Development Facilitation Team (DFT) – Review Comments

Project No: PR-2022-007397 Date: 6/11/2025 Agenda Item: #9 Zone Atlas Page: H-14

Request: Subdivide 1 existing R1D zoned lot into 2 lots

Location: 3021 11th St NW .574 acres

1 Sidewalk Exhibit
1" = 10'-0"

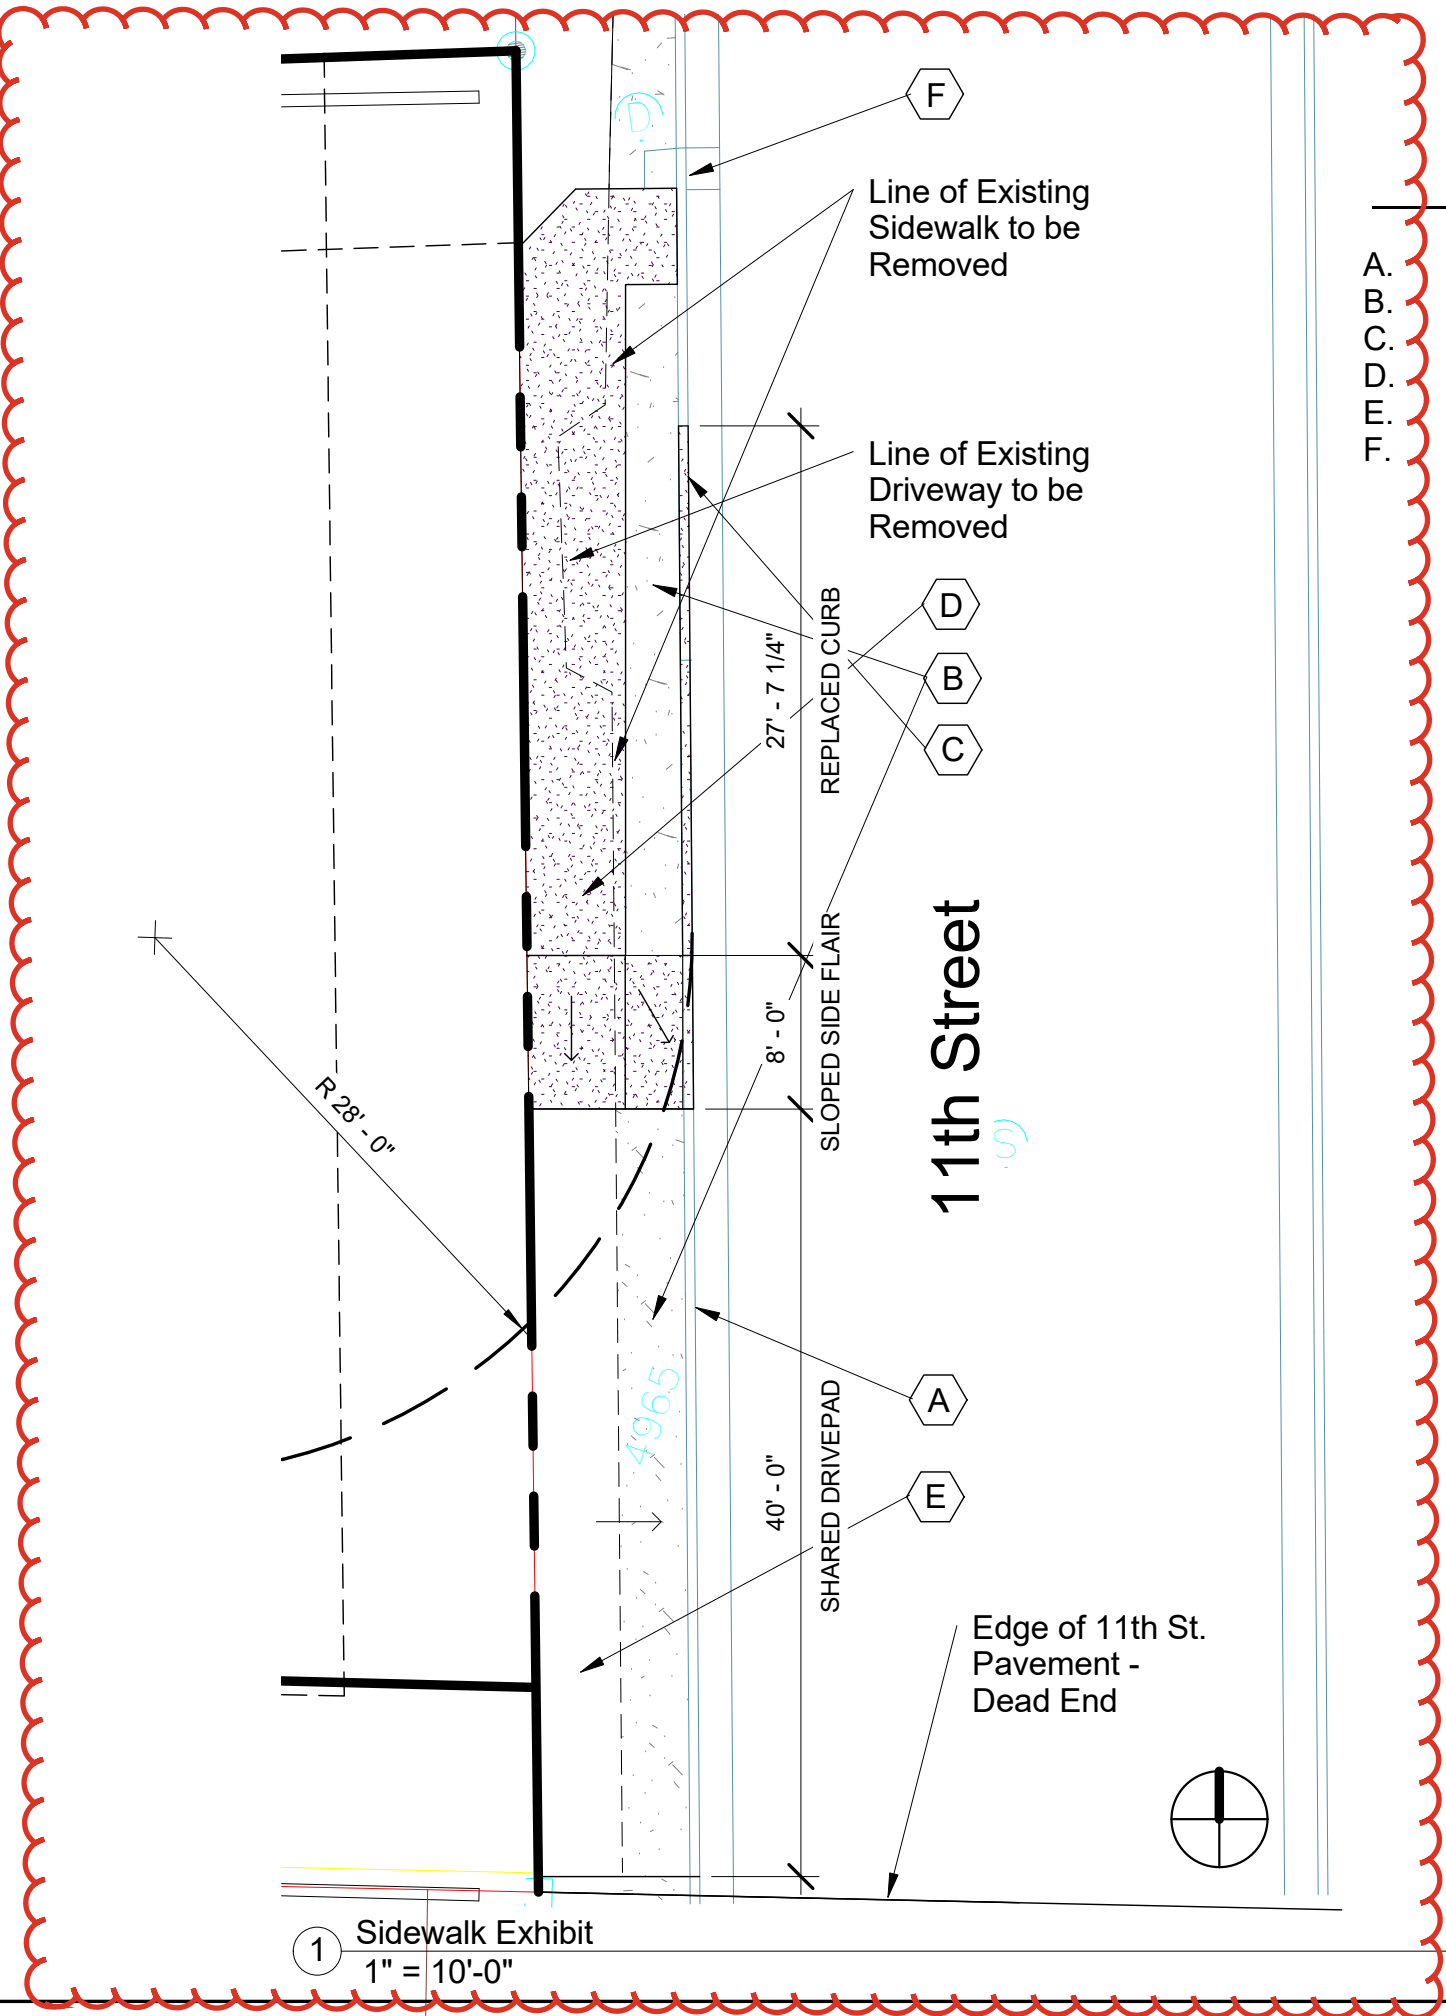
1. 11th is a local street and requires 5' sidewalk with a 4' to 6' landscape buffer. Please provide a cross section at the street dimensioning ROW, Walls or fences, sidewalk width, buffers, curb and gutter.
2. The existing driveway to this property appears as it will need to be relocated based on your proposed plat and the aerial photos.

SHEET:  
1 of 2

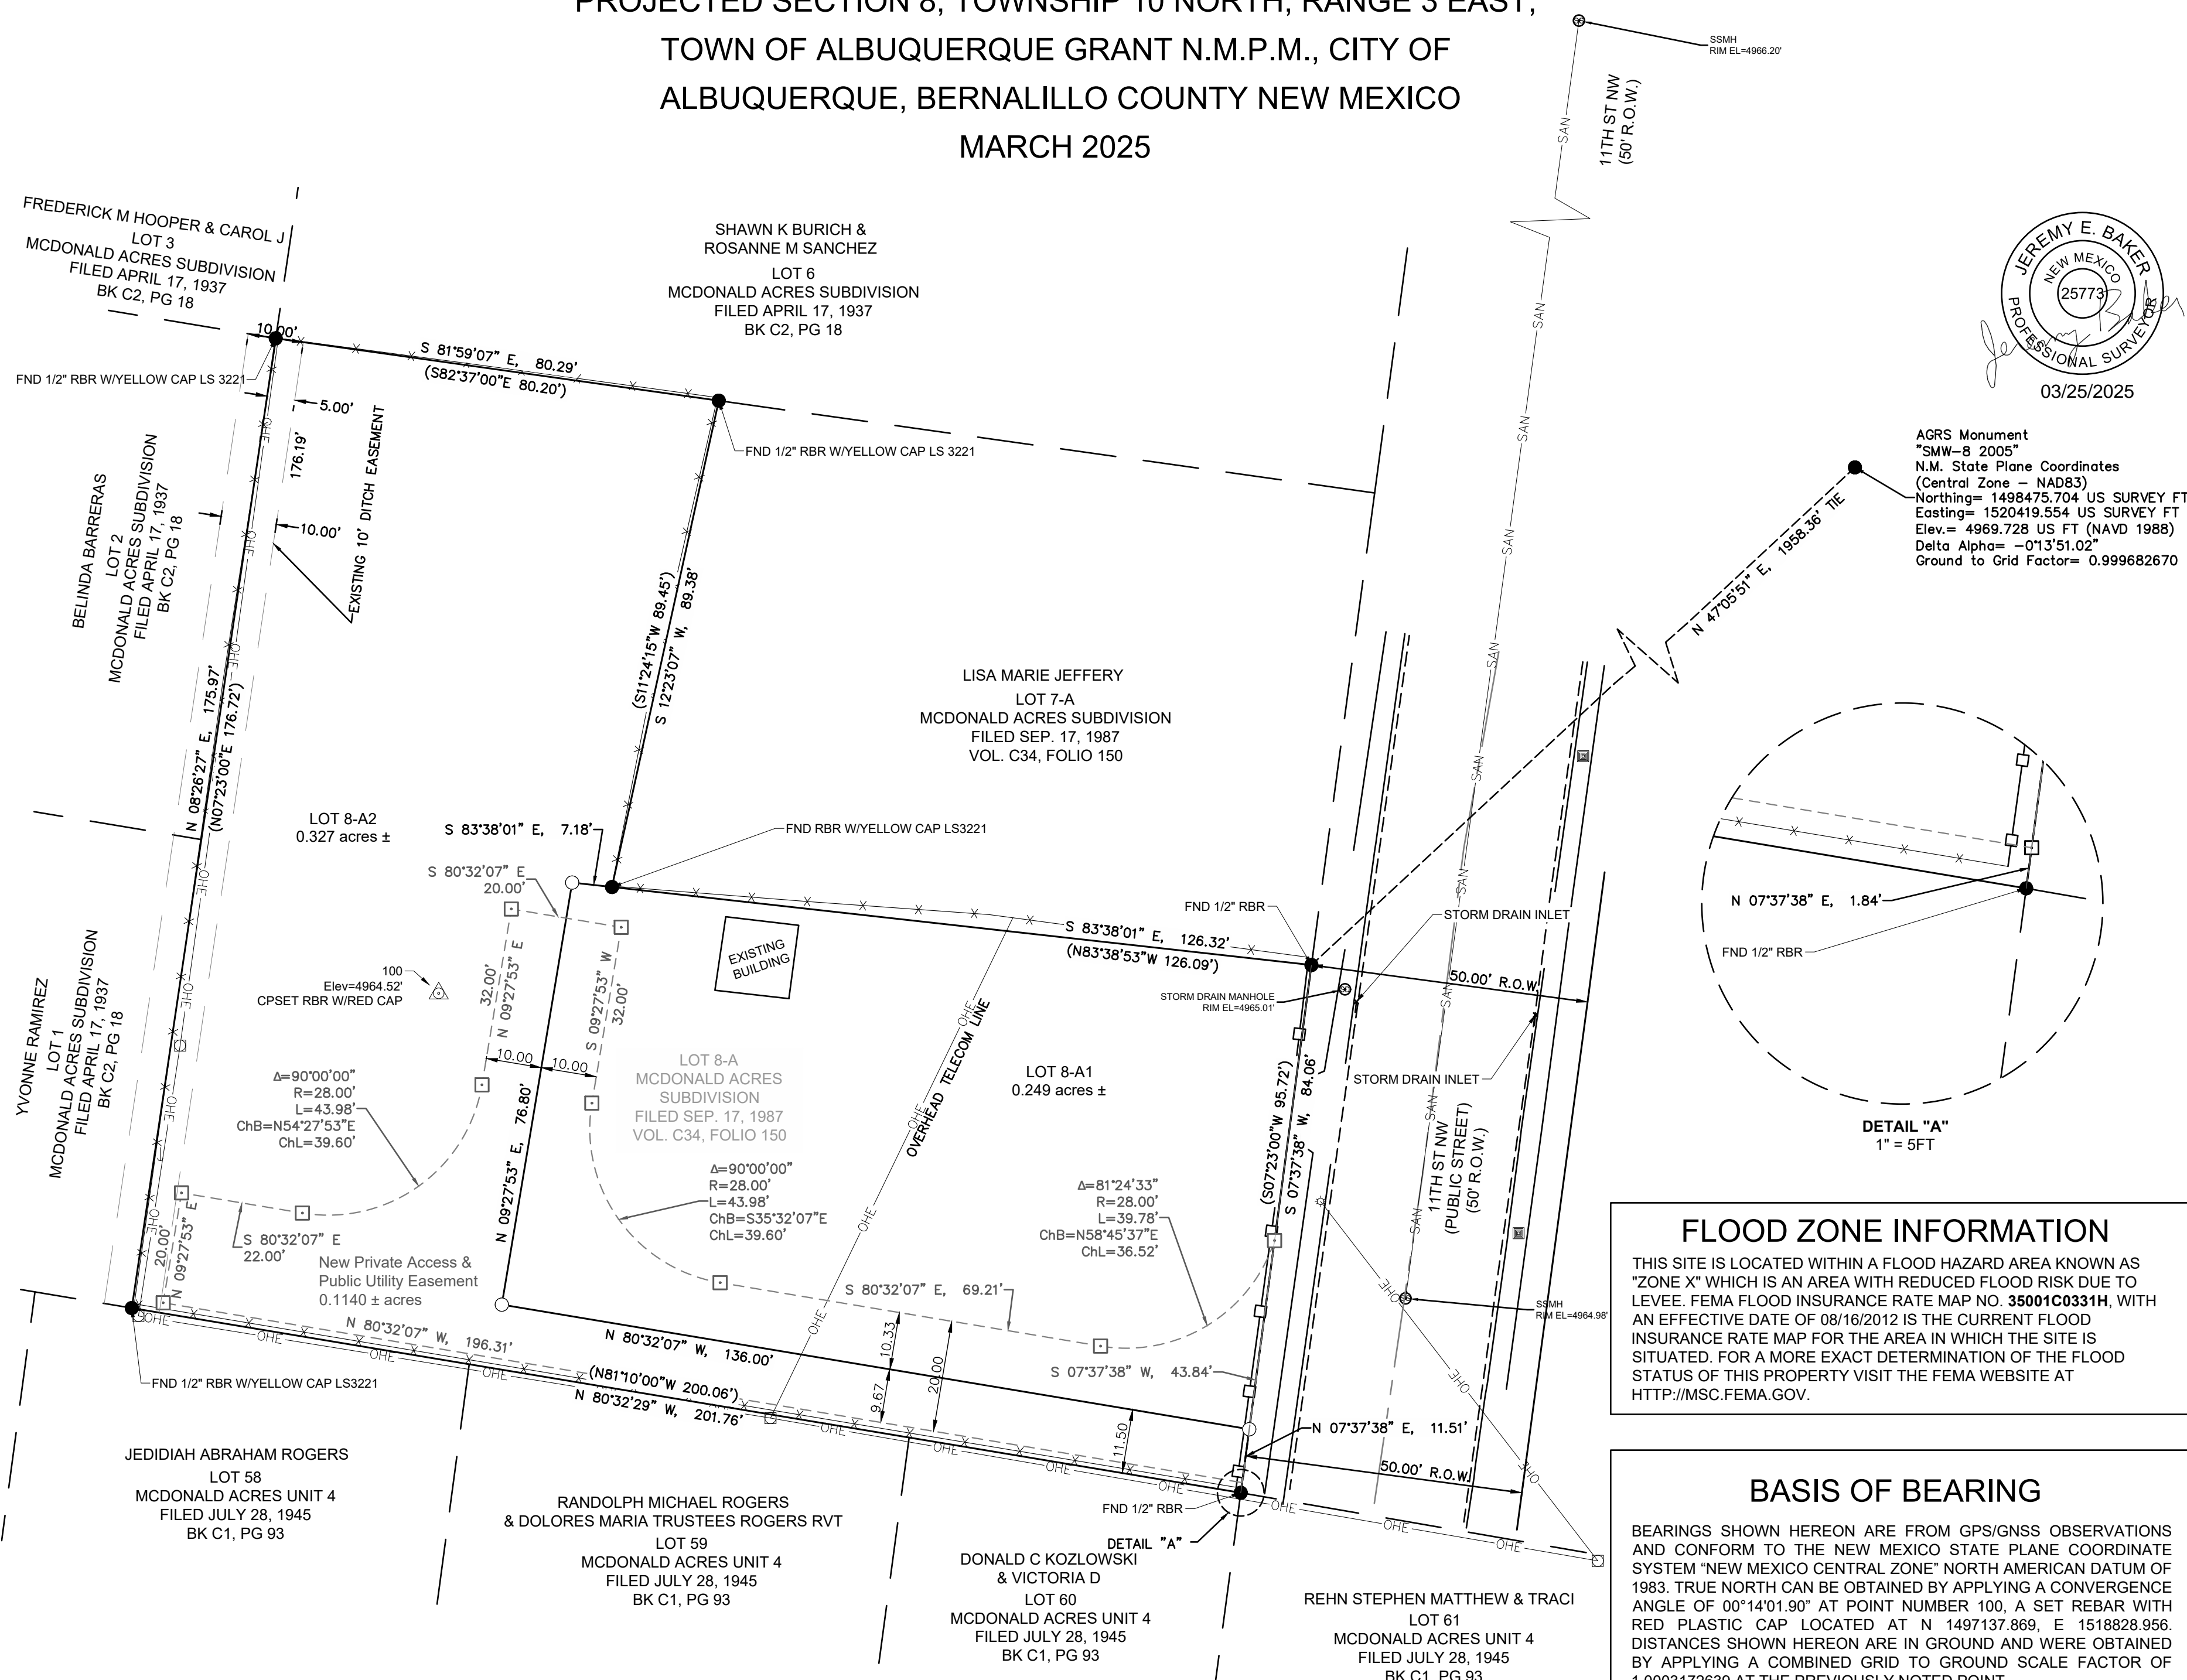
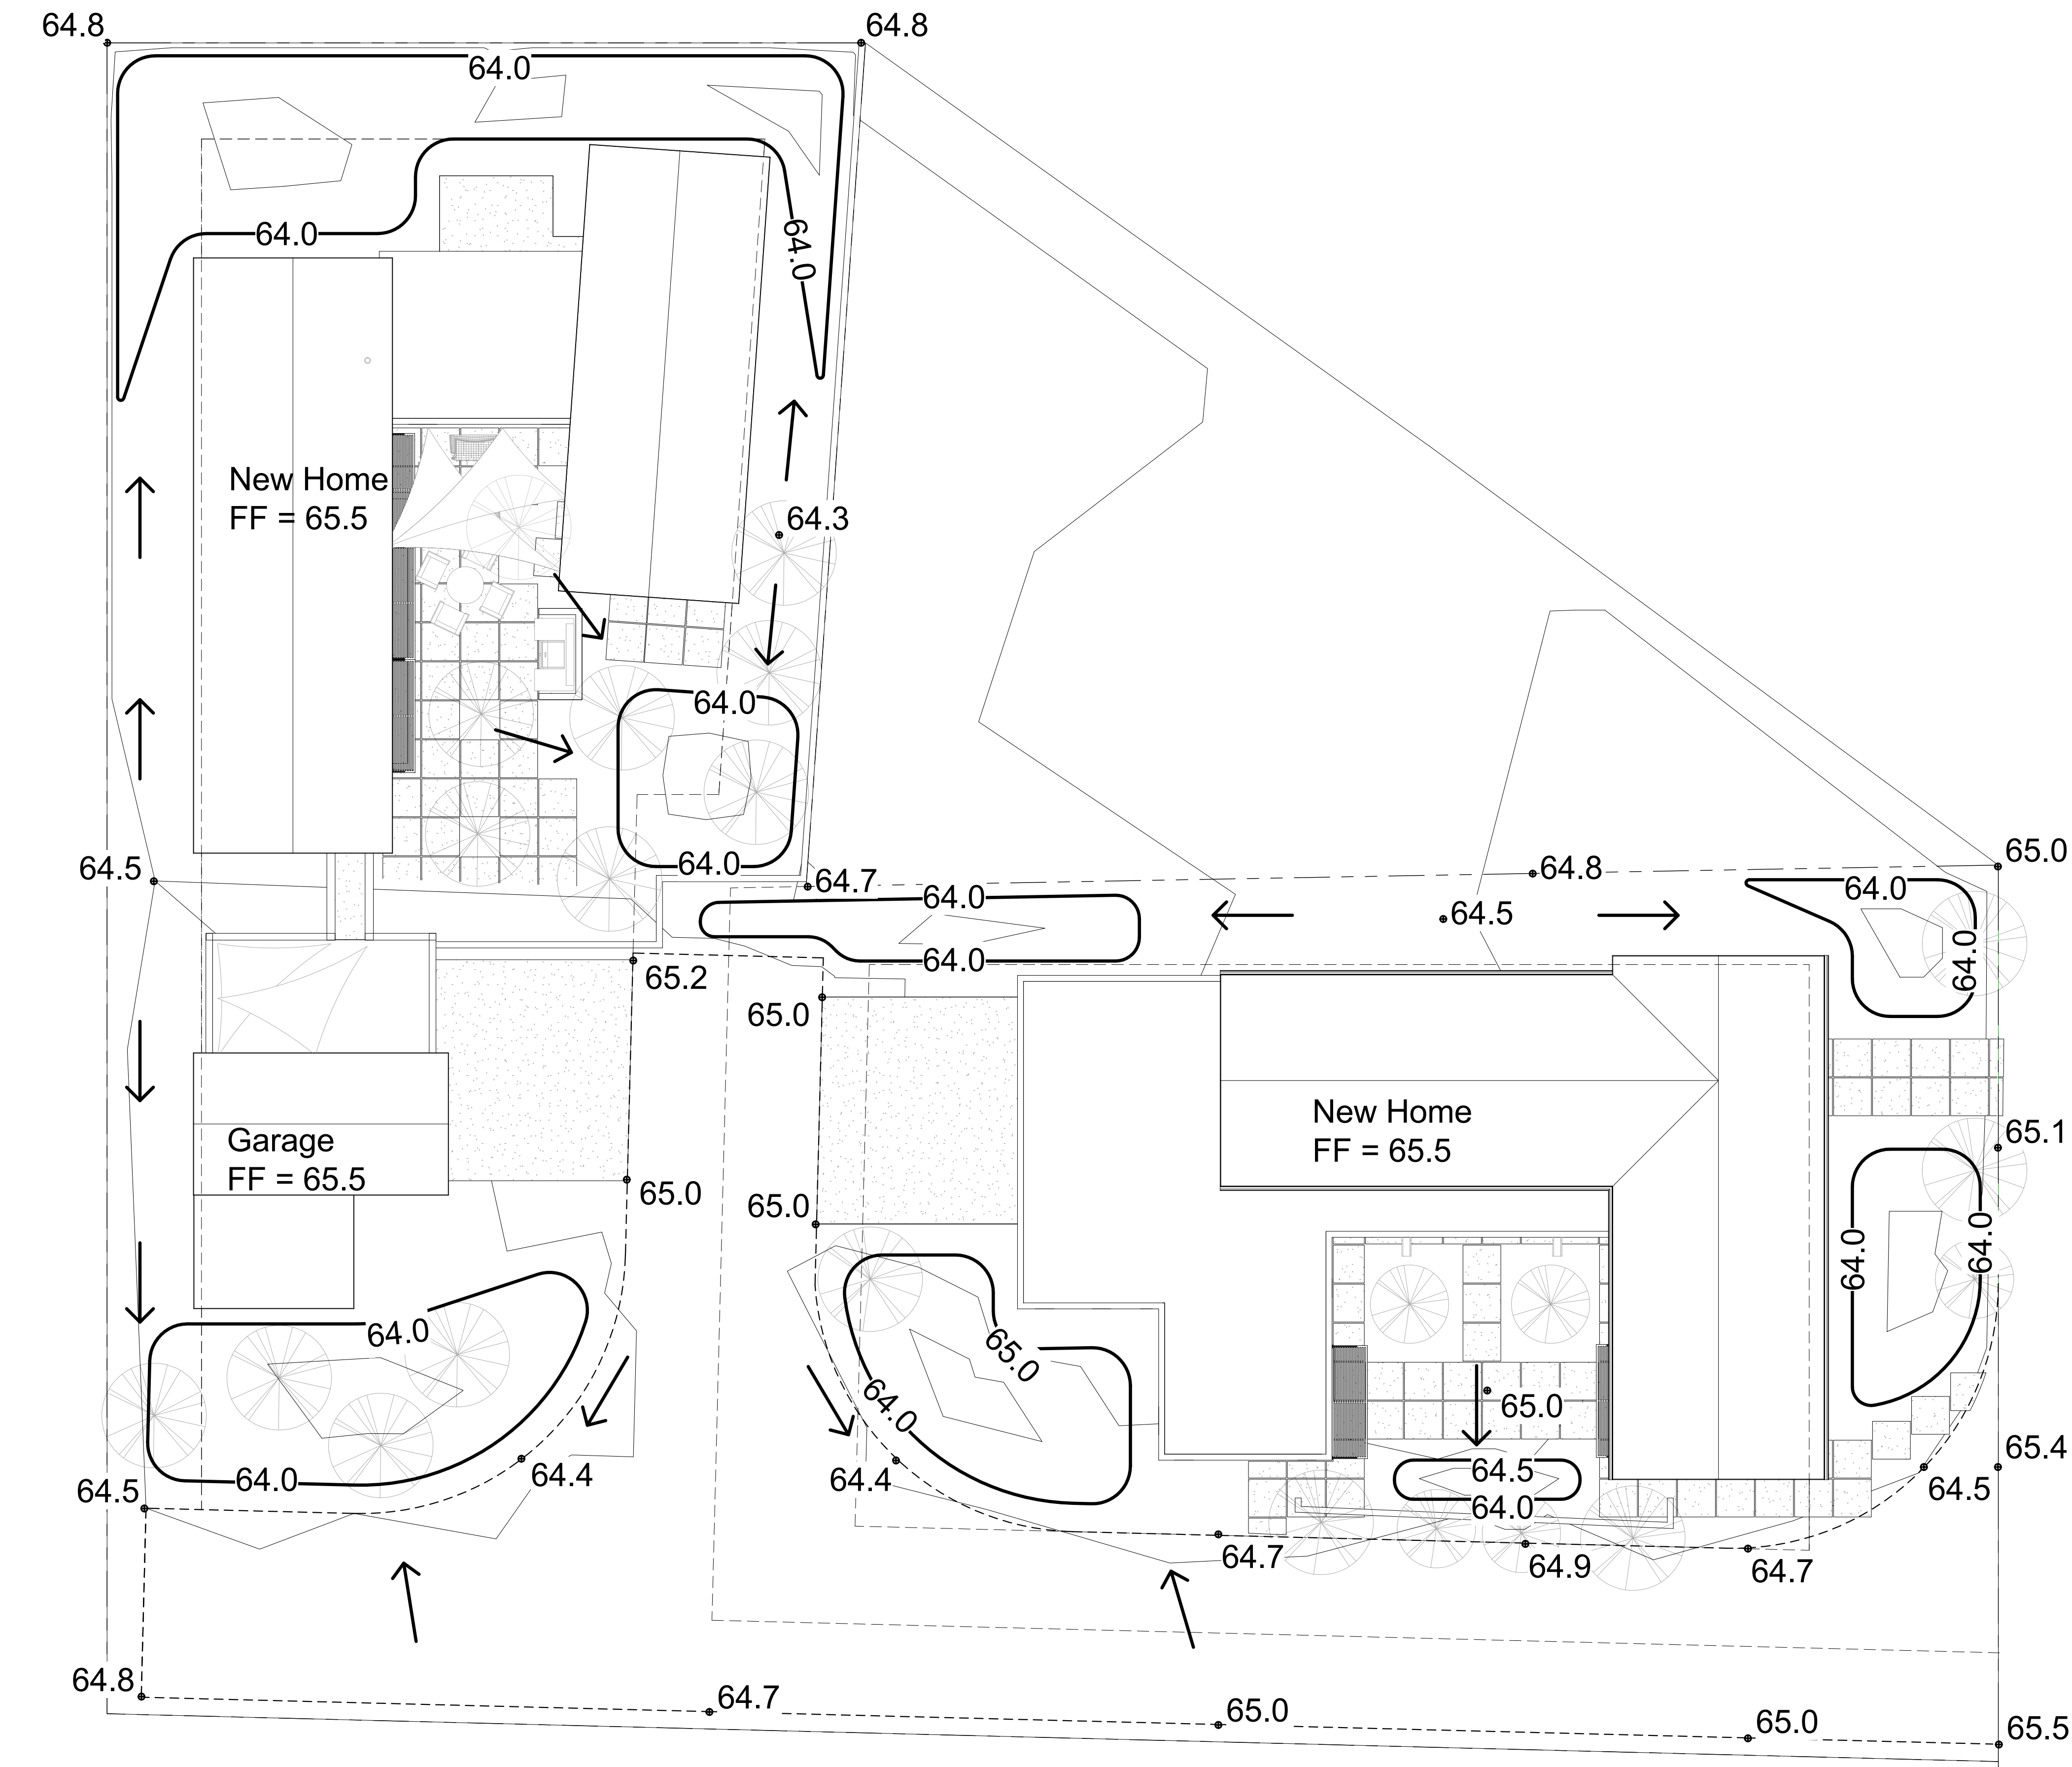
- 11th is a local street and requires 5' sidewalk with a 4' to 6' landscape buffer.
- Please provide a cross section at the street dimensioning ROW, Walls or fences, sidewalk width, buffers, curb and gutter.
- 5' sidewalk is required. All cracked and broken sidewalk and curb and gutter will need to be repaired
- The existing driveway to this property appears as it will need to be relocated based on your proposed plat and the aerial photos.

- Submit the correct platting action application in ABQ-Plan.
- Future Development must meet all applicable requirements of the IDO, DPM, or other adopted City regulations.
- Project and application numbers must be added to Plat sheets.
- The subject property is **not** located within 660 feet of Major Public Open Space and/or a tribal boundary. A Pre-Submittal Tribal Meeting request will **not** be required for future platting.
